From:
Sent: 17 February 2026 12:48
To: louise.bearcroft@kirklees.co.uk; DC Admin
Subject: Objection to Planning Application 2025/92737 and 2025/92713

Ms Bearcroft
Subject Planning Applications:
2025/61/92713/E

Comments / Concerns re the Latest Revised Plans

Client	PPJ Developments	Issued From	
Project	2539 - Moor Lane - Residential	Date	October 2025
Title	Site Sections	Scale	1:200 @ A1
Drawn	BH Auth BH	Revision

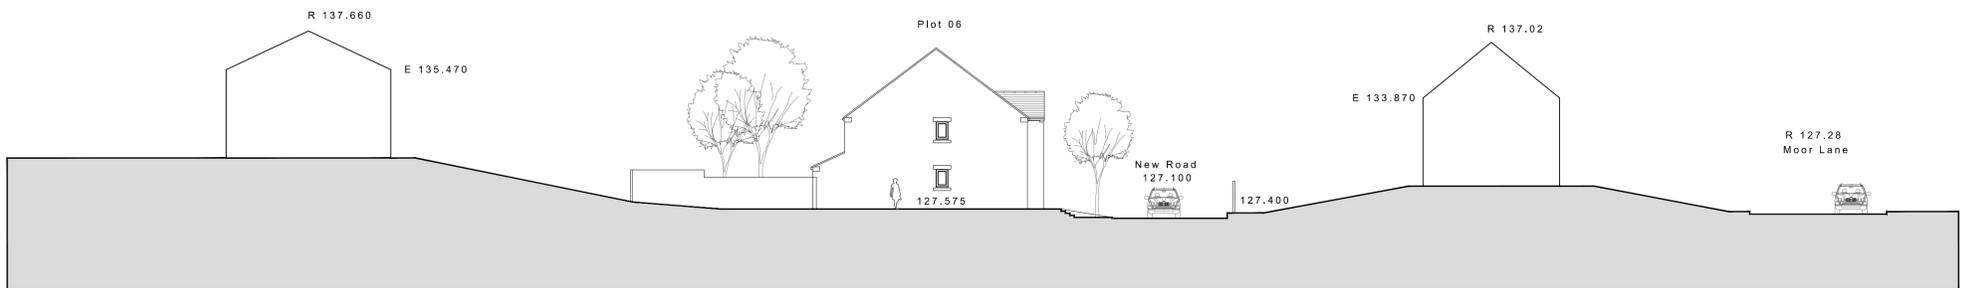
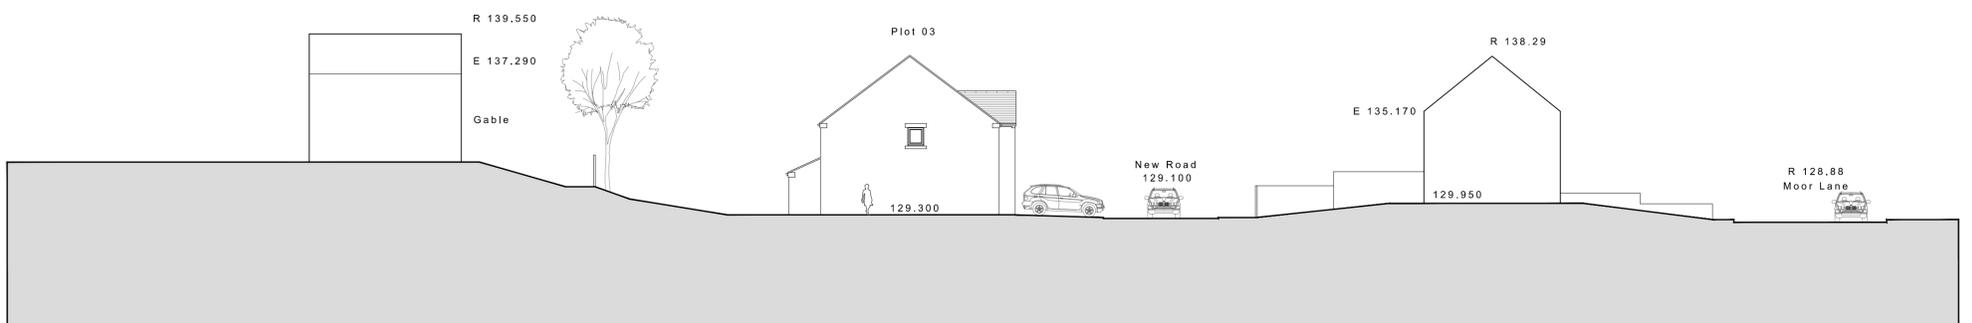
The fact of the matter is that the North East gable of Plot 10 will be only metres away from the boundary and will also be approximately 2.00 metres higher than the Ridge of 21 Summerdale.

PROPOSED SITE PLAN 1:200 @ A1

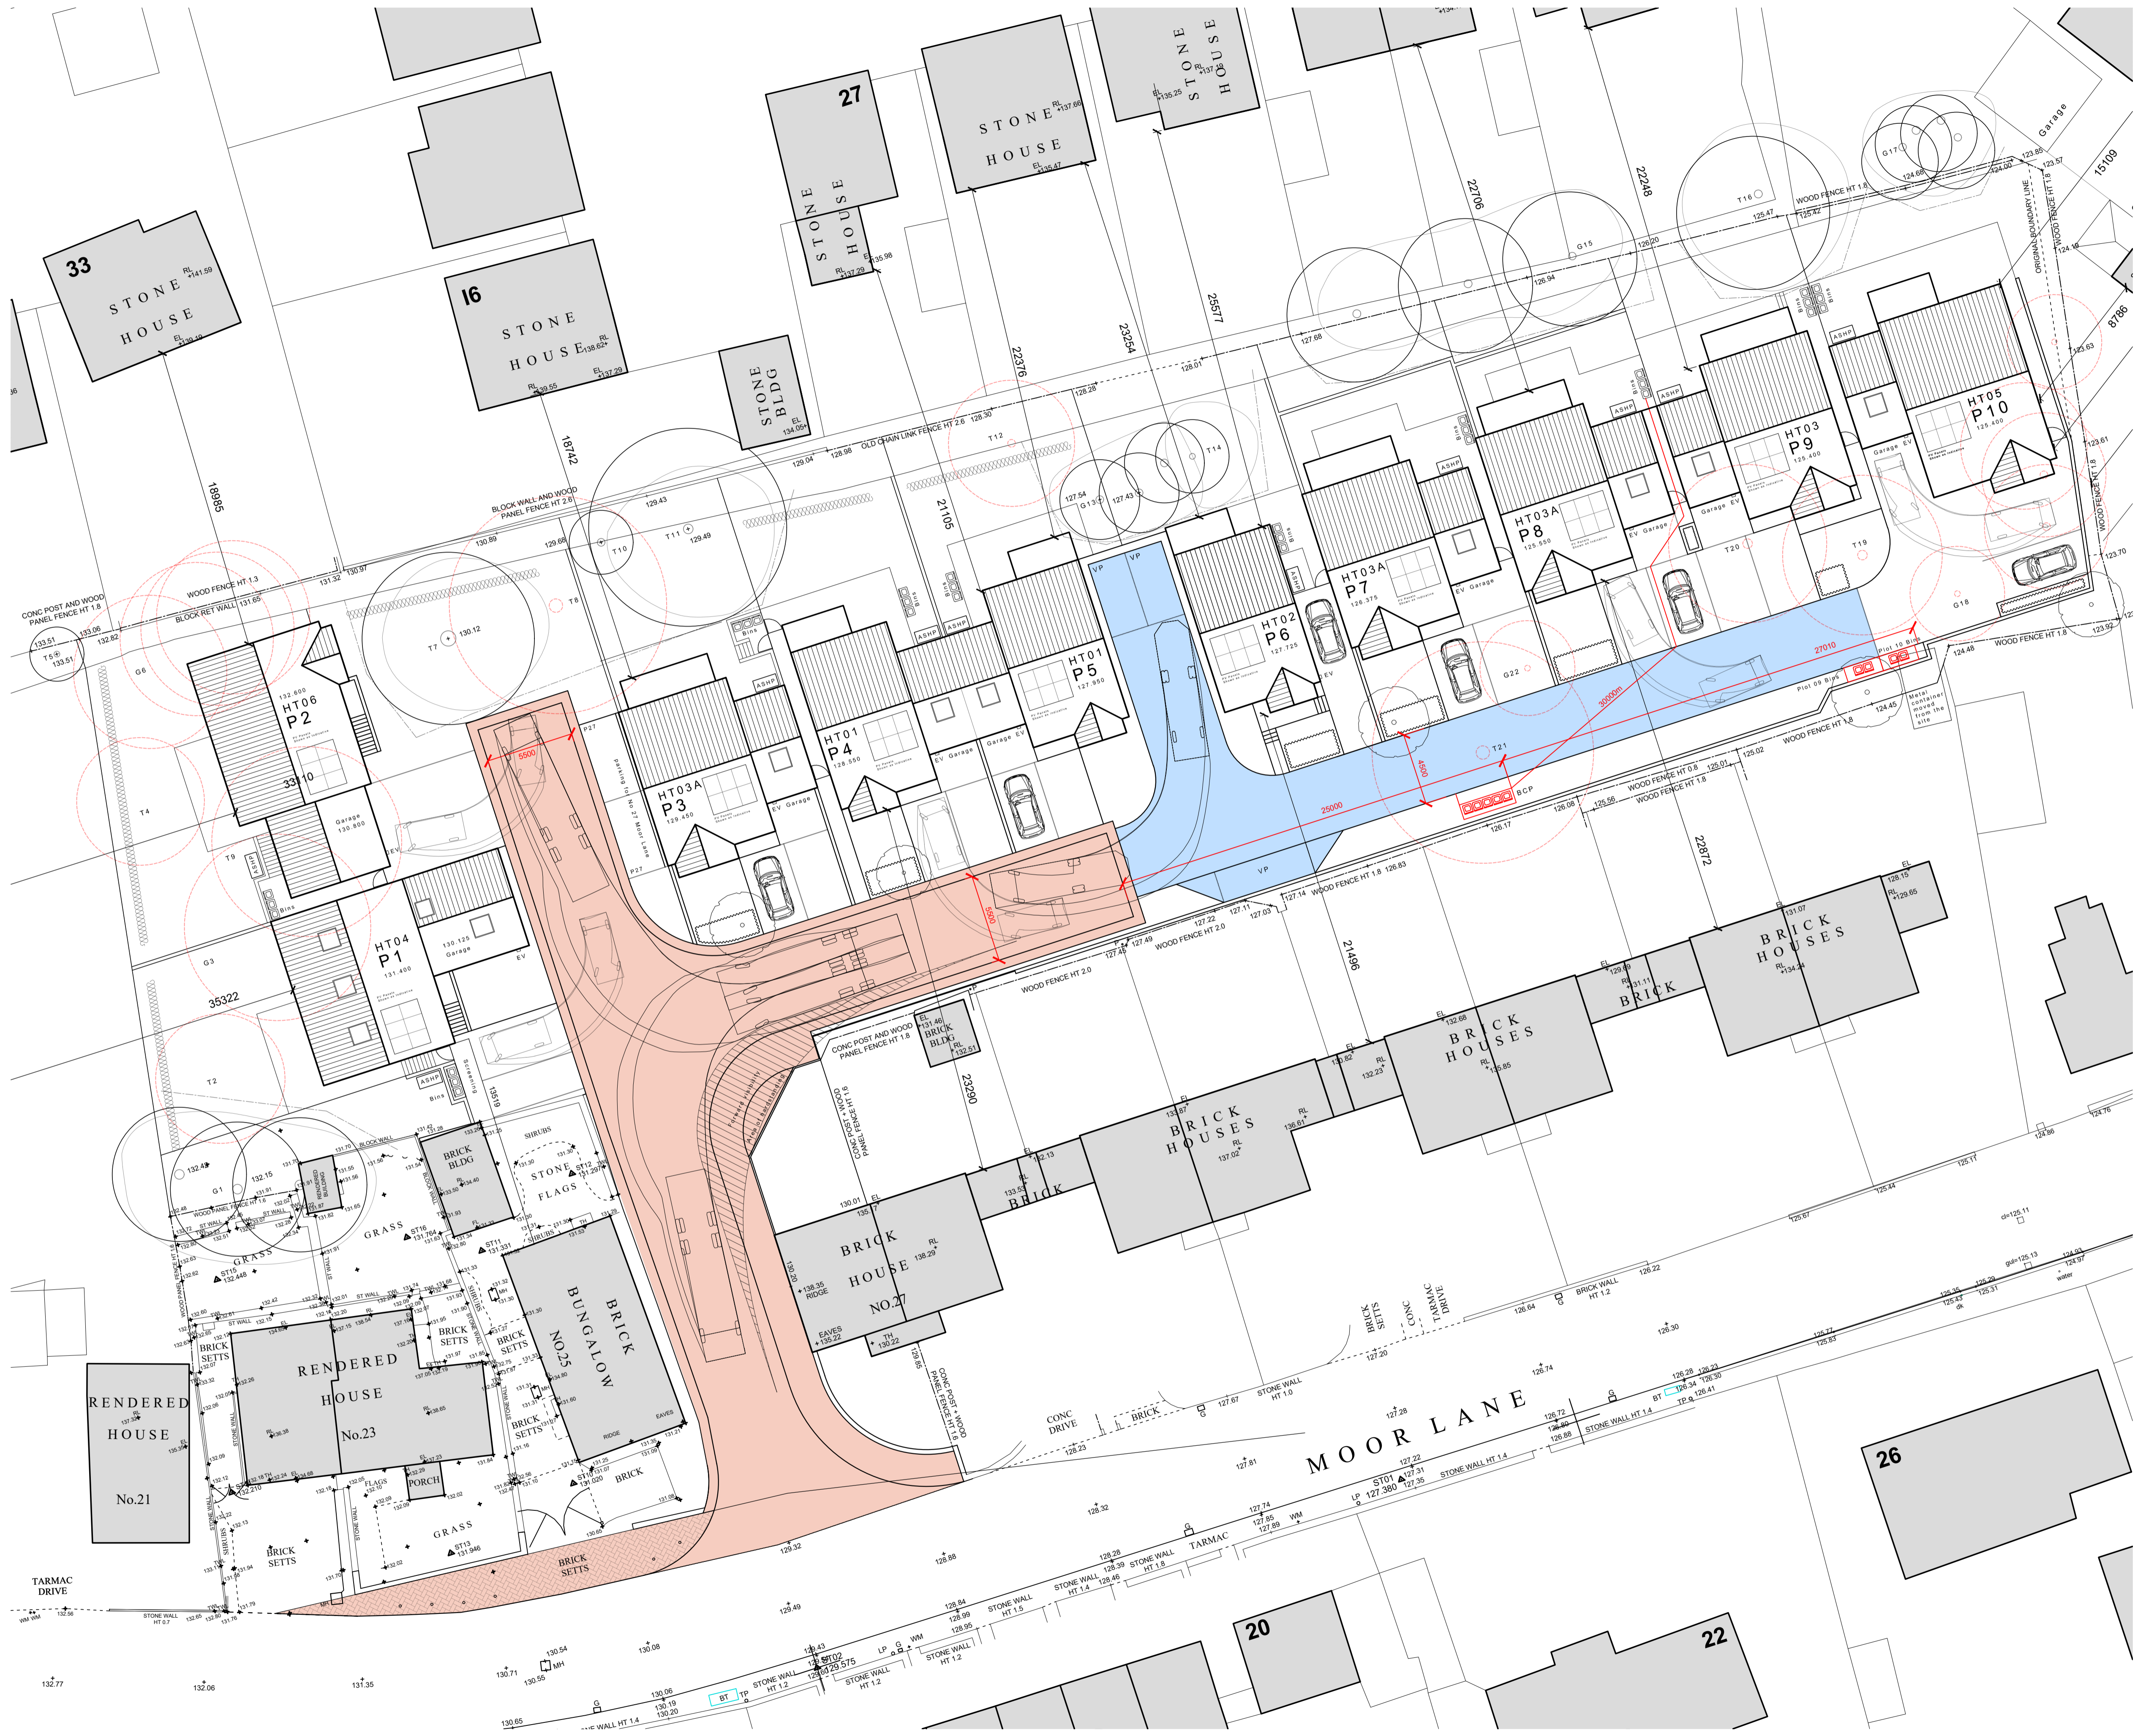
Travel distances for wheeling refuse bins still appear to exceed permitted travel distances.

Plot 3 Bin store route appears to be down the foot path belonging to Plot 4.

The Flood exceedance route is still shown routed into the private garden of 21 Summerdale, which from my research is illegal, unless permission is granted by the owner. Not only is this of major concern to them, but also other residents of Summerdale.

The 2 parking spaces for 27 Moor Lane will have to be accessed off the private block driveway of Plot 2 and seems illogical.

Also 2 visitor car parking spaces are in an equally ridiculous position, and again these are off the private block drive serving plots 7, 8, 9 and 10, which will no doubt be used by the house occupants.

There are still no “Communal Enhanced Habit Zones “ indicated on the latest plans. Originally 3 separate areas were proposed, one adjacent Plot 1, a second adjacent Plots 2 and 3, and a third adjacent Plots 5 and 6 totalling 465m²

Plot 10 is shown as being 8.876 metres away from No 21 Summerdale measured at an angle towards their property. However, they have not shown the conservatory that is only a metre or so away from the boundary.

A measurement of 15.109 metres is shown to No 23 Summerdale which is totally irrelevant and has no bearing on the issue.
